Reference No:	2024/62/92731/E
Site Address:	631, Hunsworth Lane, East Bierley, BD4 6PU
Description:	Erection of first floor side extension and front porch
Recommending Officer:	Faiza Bano

HOUSEHOLDER DELEGATED REPORT

Application Number	2024/92731
Location	631, Hunsworth Lane, East Bierley, BD4 6PU
Proposal	Erection of first floor side extension and front porch
Publicity end date	11 th November 2024
Number of representations received	None
Kirklees Local Plan Allocation/Designation	Unallocated in the Kirklees Local Plan.
Extension to Time (EoT)	No
Recommendation	Conditional Full Permission

Drawing Title
PROPOSED

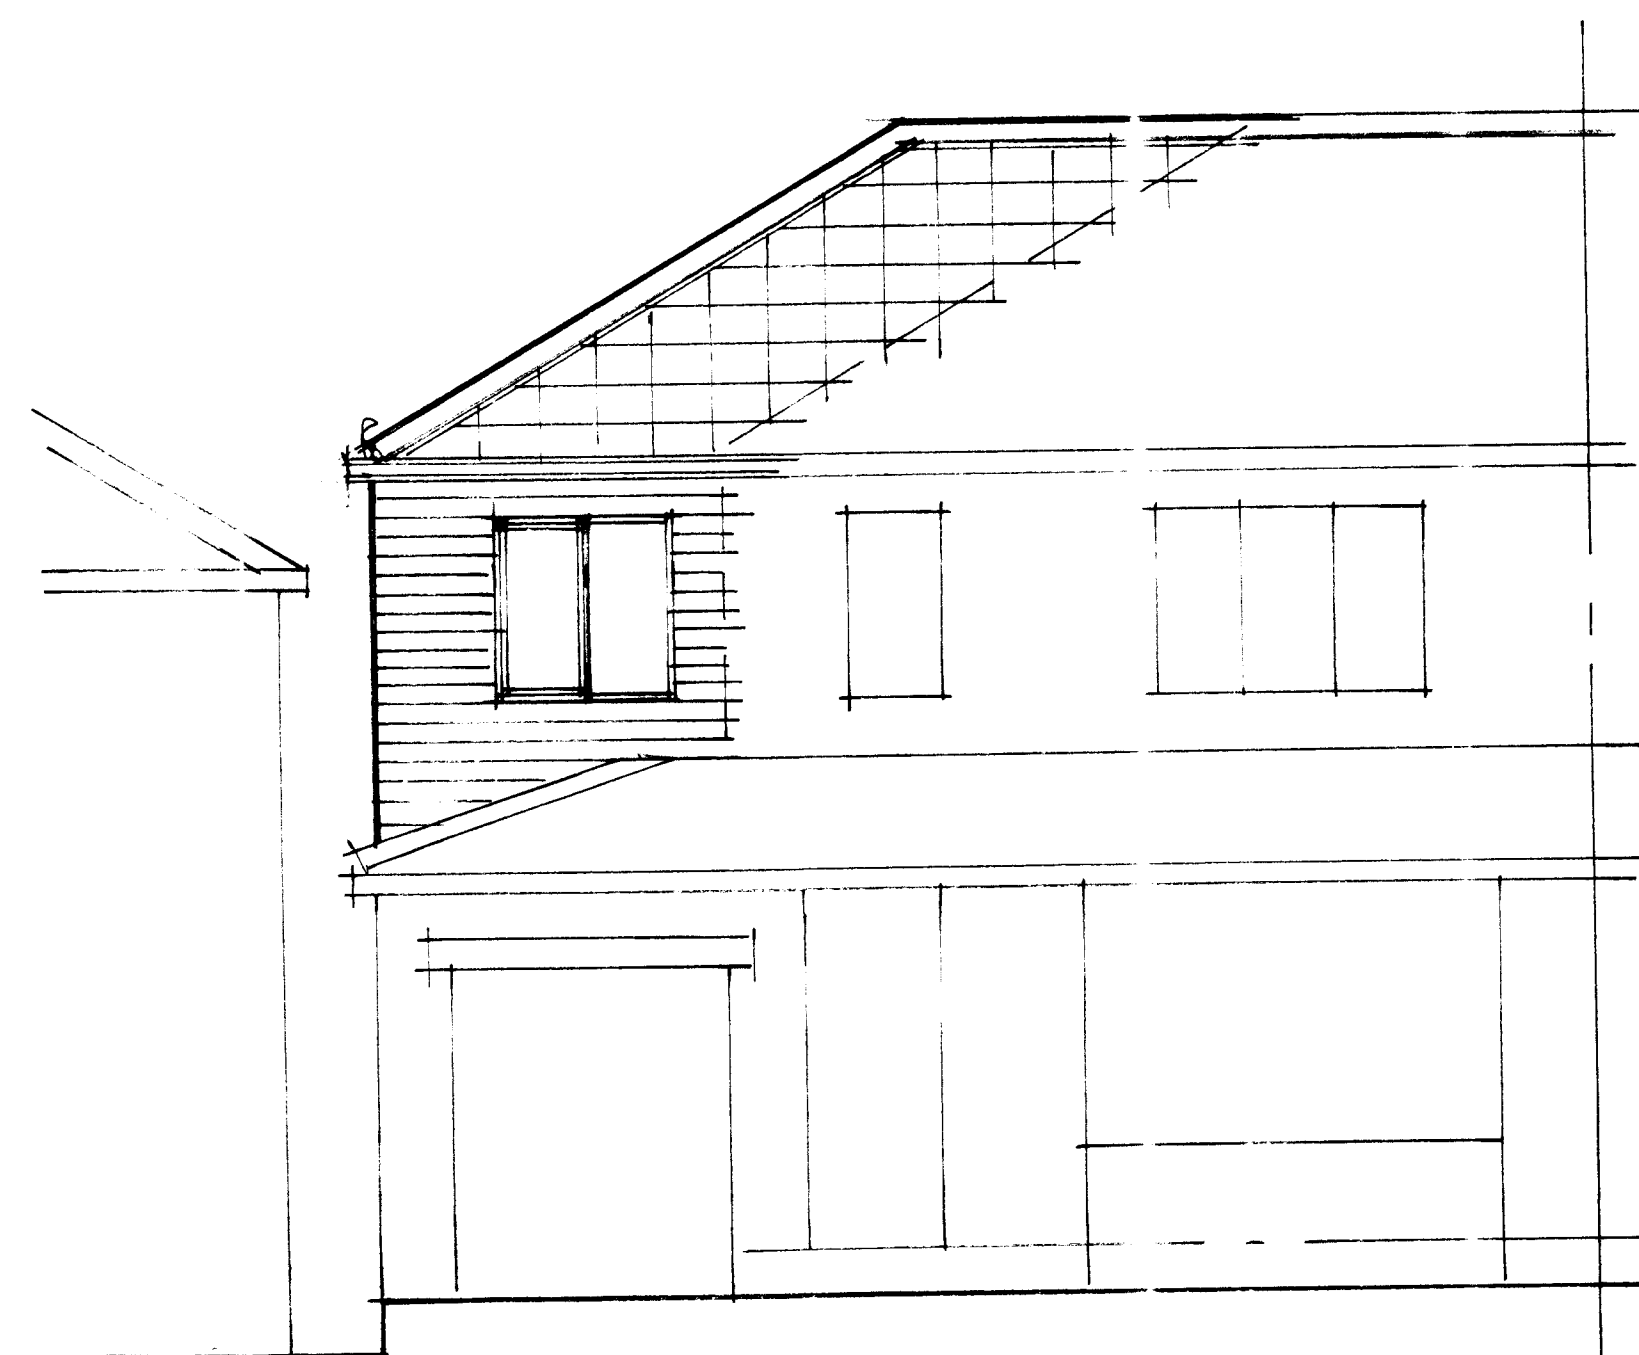
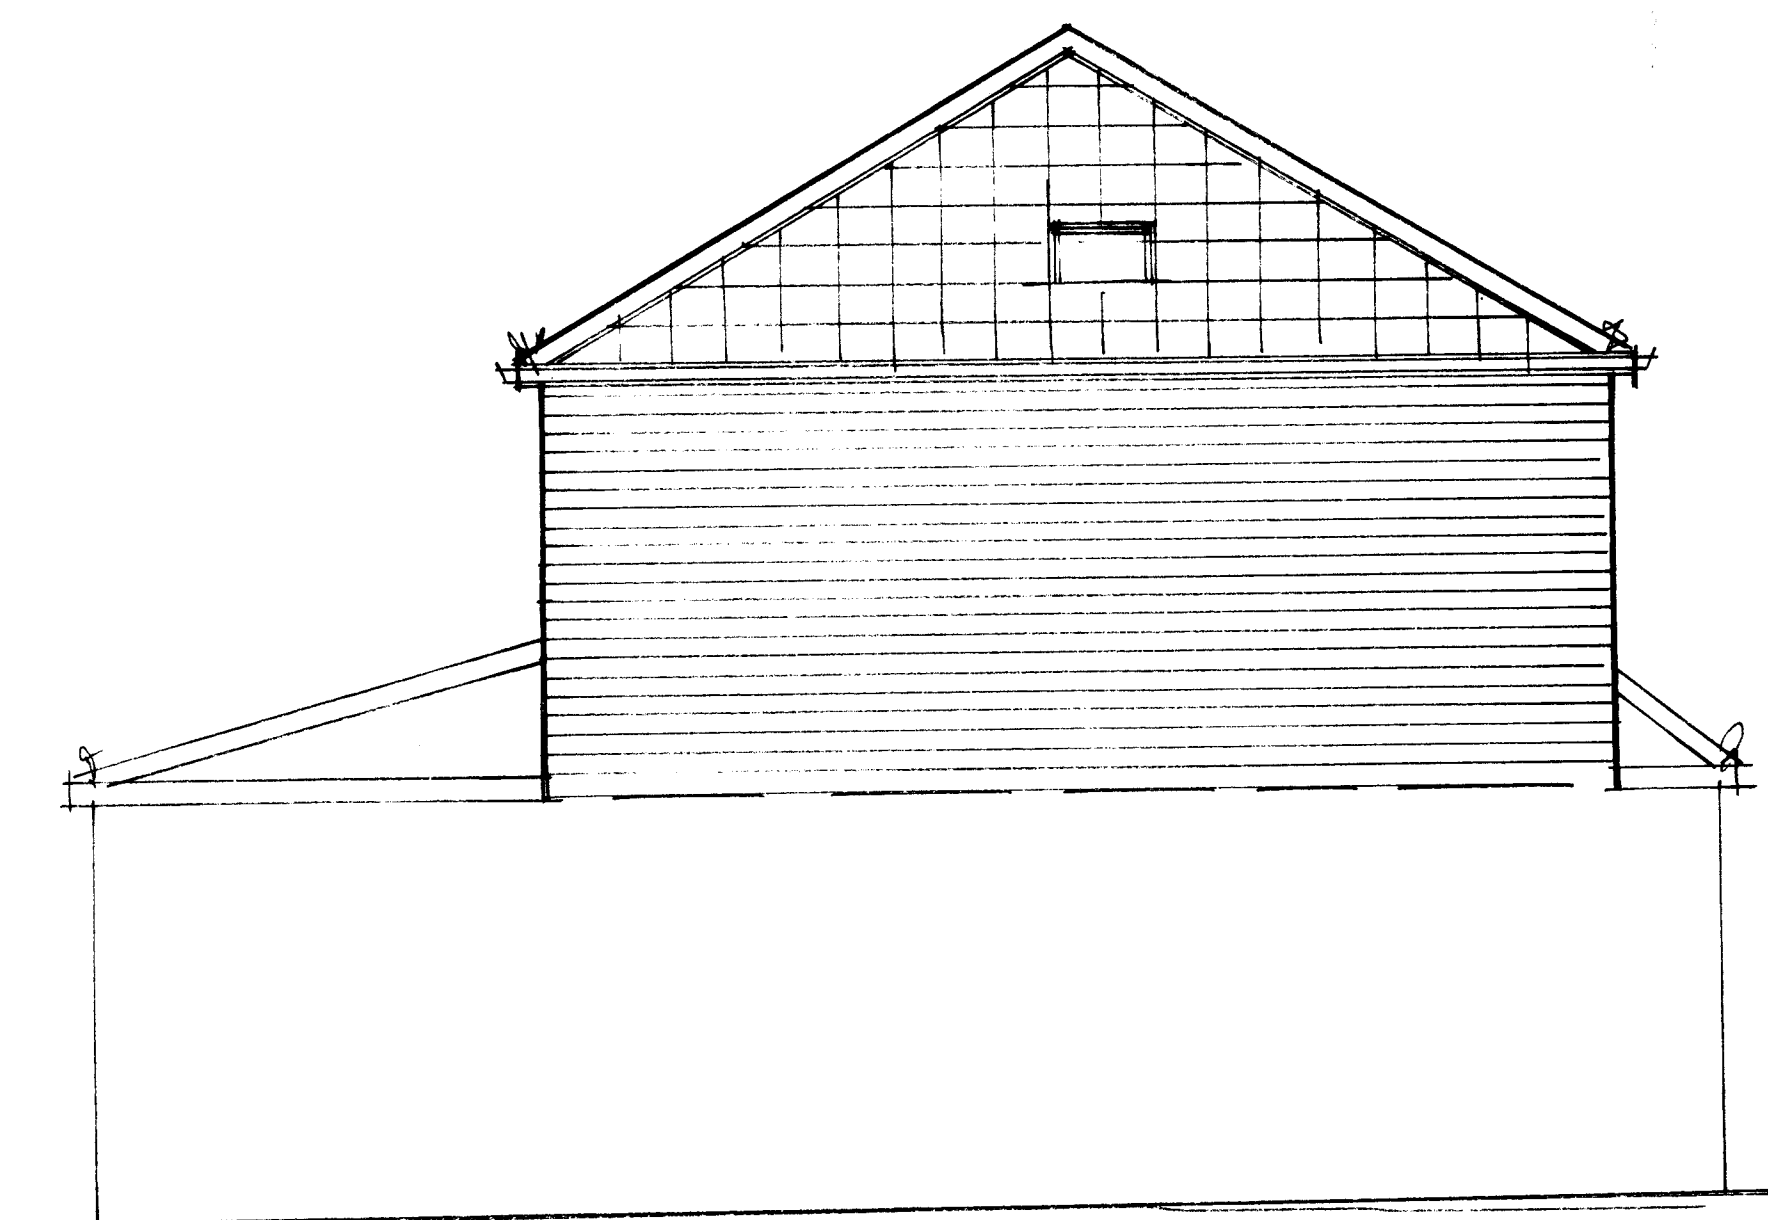
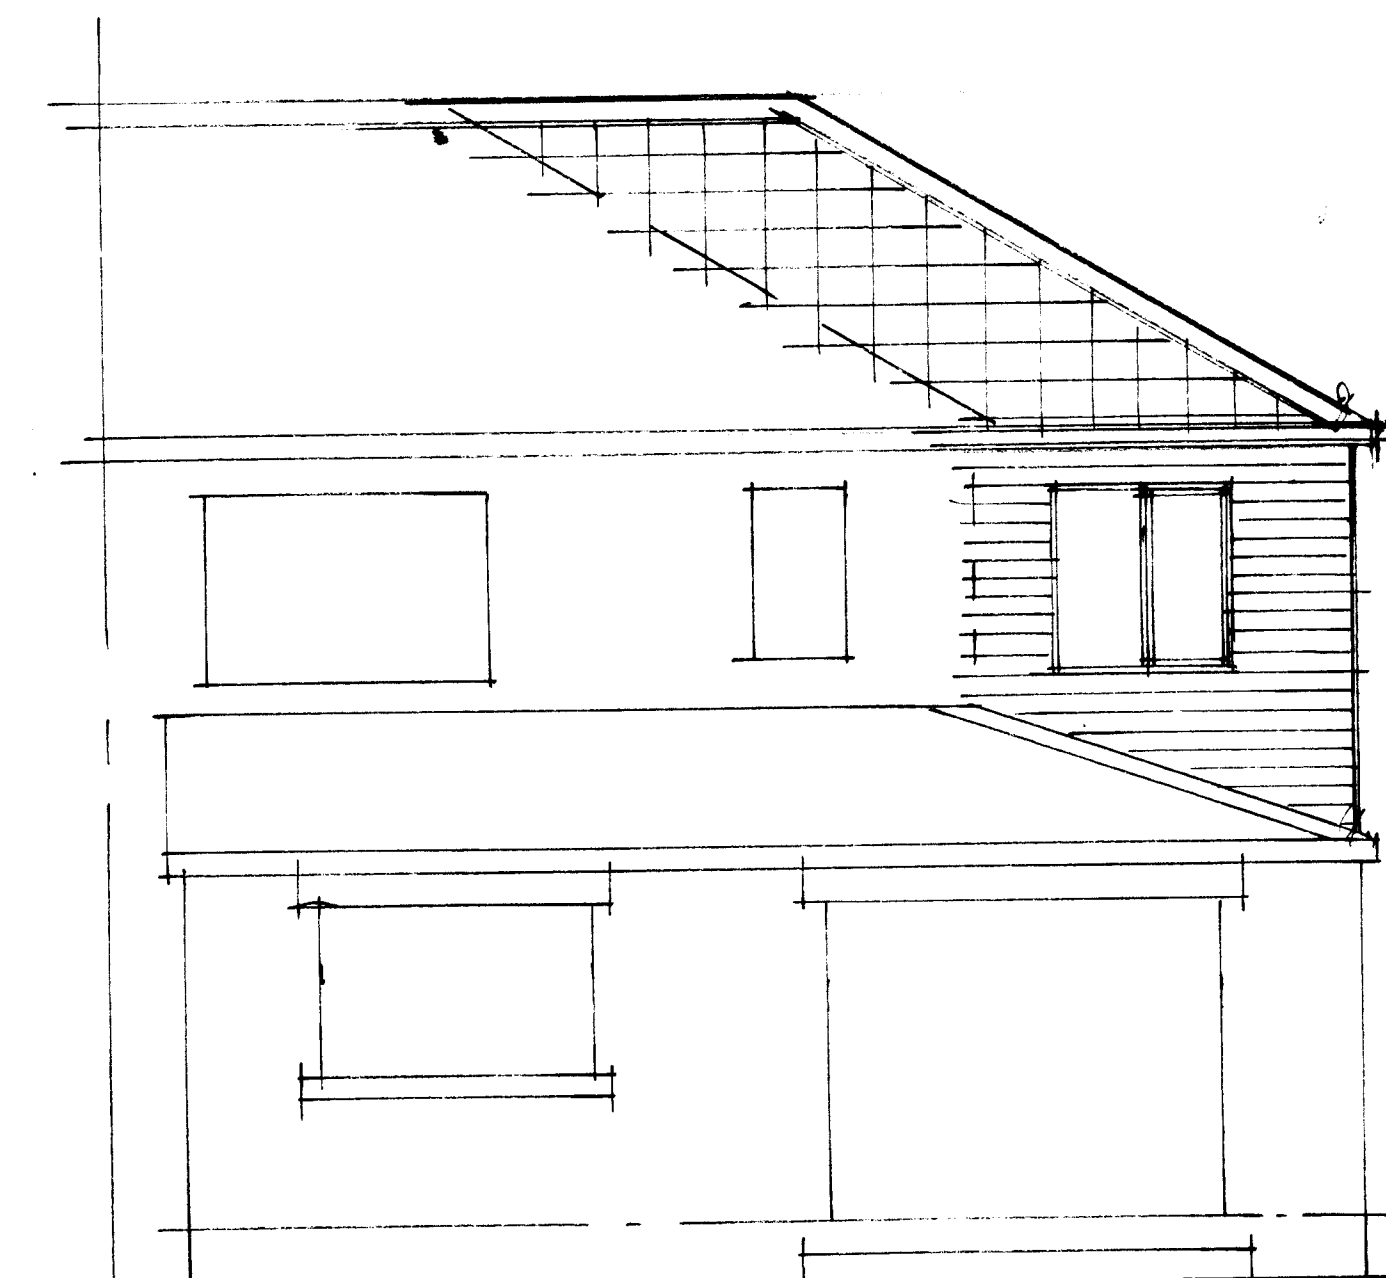
Side extensions should:	<u>Yes - COMPLY</u>	<u>No - JUSTIFY</u>
Ensure reasonable levels of natural light to the habitable rooms in neighbouring properties	Proposed extension is set back from the frontline of neighbouring property 629, it does not overshadow any windows of neighbouring properties, thus, ensures no significant impact to the levels of natural light neighbouring properties receive.

Positioning windows to minimise or avoid any potential overlook into neighbouring gardens	As the first floor of the property is set back from the front elevation of the ground floor and neighbouring dwelling, the outlook from the proposed bedroom window will have no significant impact upon the neighbouring property.	
Two storey side extensions should:		
Not take up all or most of the space to the side of a house		The first-floor extension would not be small in size but remain subservient to the existing building on site. The width of this extension would be limited to the width of the existing single storey side extension. It is also noted that several semi-detached properties nearby have had an extension of a similar size, including the adjoining semi. The proposed side extension would mirror this and balance the symmetry of the pair. Acknowledging that, it is considered that the scale of development as proposed could be supported from a visual amenity perspective in this instance.

maintain a 1 metre gap to the side boundary to ensure the building is not too close to a neighbouring property		As outlined above, whilst not maintaining a 1m gap, the lack of a gap of this scale has been established by the existing ground floor

side extension and is therefore acceptable in this instance.
be set back at least 500mm from the front wall of the house		The proposal is not set back from the front wall of the house, however, the neighbouring property, 629, has erected a similar two-storey extension that also lies flush with the front elevation of the building. As a result, the proposed extension would not adversely affect the character of the street and is acceptable in this instance.

Single storey front extensions:	<u>Yes - COMPLY</u>	<u>No - JUSTIFY</u>
The house is set well back from the pavement or is well screened; and	Yes – the house is well setback from the pavement. It benefits from a front garden that includes a drive way.	
The extension is small, subservient to the original building, well-designed and would not harm the character of the original house or the area; and	Yes – the extension would appear subservient and has been designed with a pitched roof, in-keeping with host property.	
The materials and design match the existing features of the original house; and	Yes – materials would match existing	
The extension would not unreasonably affect the neighbouring properties.	Yes – the modest scale would result in minimal impact on neighbouring property.

Height, scale and massing	• KDP 1 and 2 of the SPD • Policy LP24 Design (a), (c) and (d) of the KLP • Chapter 12 of the NPPF	Two-storey in height and lies flush to the original building, appearing proportionate to the host property.	✓
Facing materials and detailing	• KDP 9 of the SPD	Brickwork and uPVC doors and windows are to be used, matching the existing building.	✓

• Policy LP24 Design (d) (iii) of the KLP • Chapter 12 of the NPPF		
Roof style	• KDP 1 and 2 of the SPD • Policy LP24 Design (a), (c) and (d) of the KLP • Chapter 12 of the NPPF	A tiled roof will be used on the extension to match the existing building.	✓
Window proportions	• KDP 1 and 2 of the SPD • Policy LP24 Design (a), (c) and (d) of the KLP • Chapter 12 of the NPPF	Proposed uPVC windows and doors to the front and rear of the property are in proportion with those existing and well-aligned.	✓
Accessibility for all users	• KDP 17 of the SPD • Policy LP24 Design (f) • Chapter 12 of the NPPF	Private domestic extension – no amendments are to be made regarding accessibility.	✓

• 629 Hunsworth Lane – Adjacent property and shall see the construction of a first-floor extension, to include a window in the front elevation, and the erection of a front porch. 629 Hunsworth Lane has a similar extension and due to the space and relationship no issues would arise from overlooking, overshadowing/loss of light or overbearing impact.
